Our ref: WA/2020/127698/02-L01
Your ref: 20/00574/F
Date: 12 June 2020

Installation of a Standalone Solar PV Array, Associated Infrastructure, Grid Connection, Access and Landscaping

Land North Of Hill Farm, Hill Farm Lane, Duns Tew, OX25 6JJ

Environment Agency Position - Maintain objection

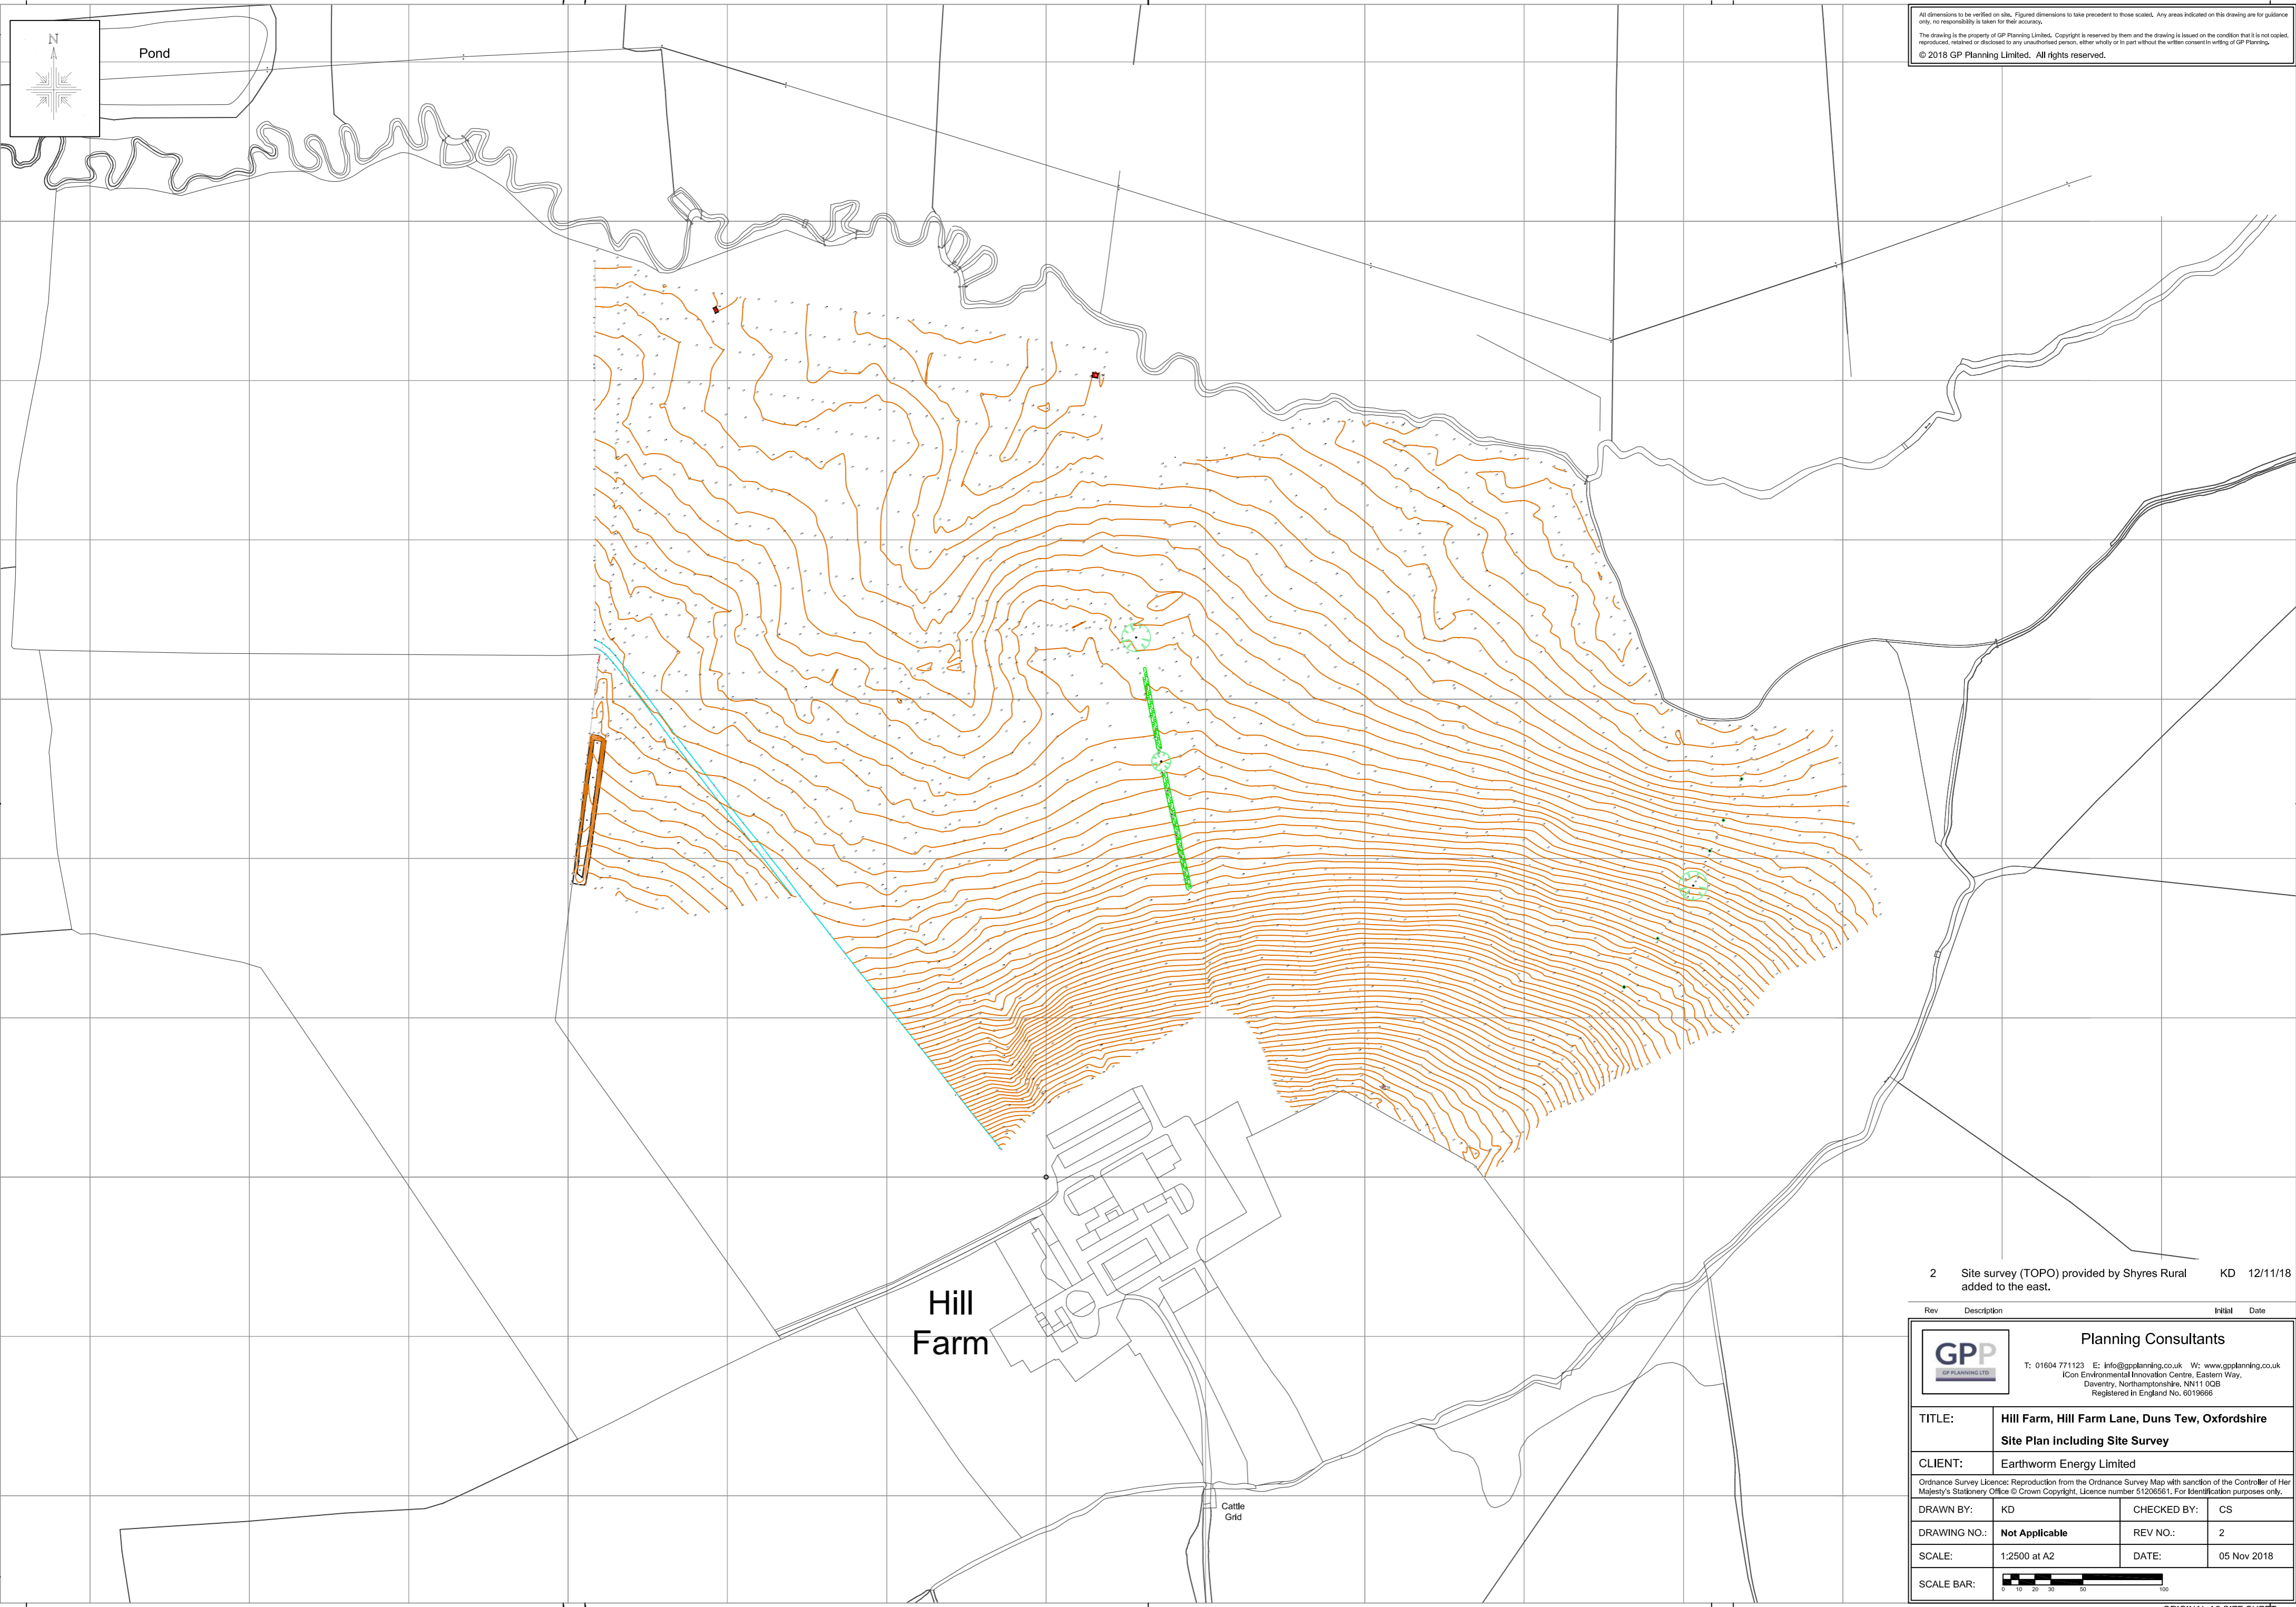
The Environment Agency assess development applications based on their red line boundary and the flood zones located within this boundary. This development application contains flood zones 2 and 3 on the site. We request that the applicant undertake detailed flood modelling of the site to determine an accurate climate change flood level for the site and submit this to us for detailed review.

Specifically, whilst it is acknowledged that all built development is proposed to be located outside of flood zones 2 and 3, the application site (as denoted by the red line boundary) remains in flood zones 2 and 3. The applicant has not determined an accurate climate change flood level for the site.

Based on current Environment Agency climate change guidance, a detailed assessment of climate change should be undertaken for the site. This will take the form of an updated hydraulic model. This will be based on the scale, vulnerability and flood zones attributed to the site (as denoted by the red line boundary) and development. The applicant should use relevant guidance to determine what would be a suitable climate change allowance for the site. The model will need to be submitted to the Environment Agency for review.

As previously advised, if the applicant does not wish to undertake detailed modelling, and wants to adjust the development application so the development site avoids flood zones 2 and 3, then they should consider submitting an alternative application with the site located entirely within Flood Zone 1.

To overcome our objection, the applicant should submit a revised FRA which addresses the points highlighted above and contained in our original objection dated 27 March 2020.
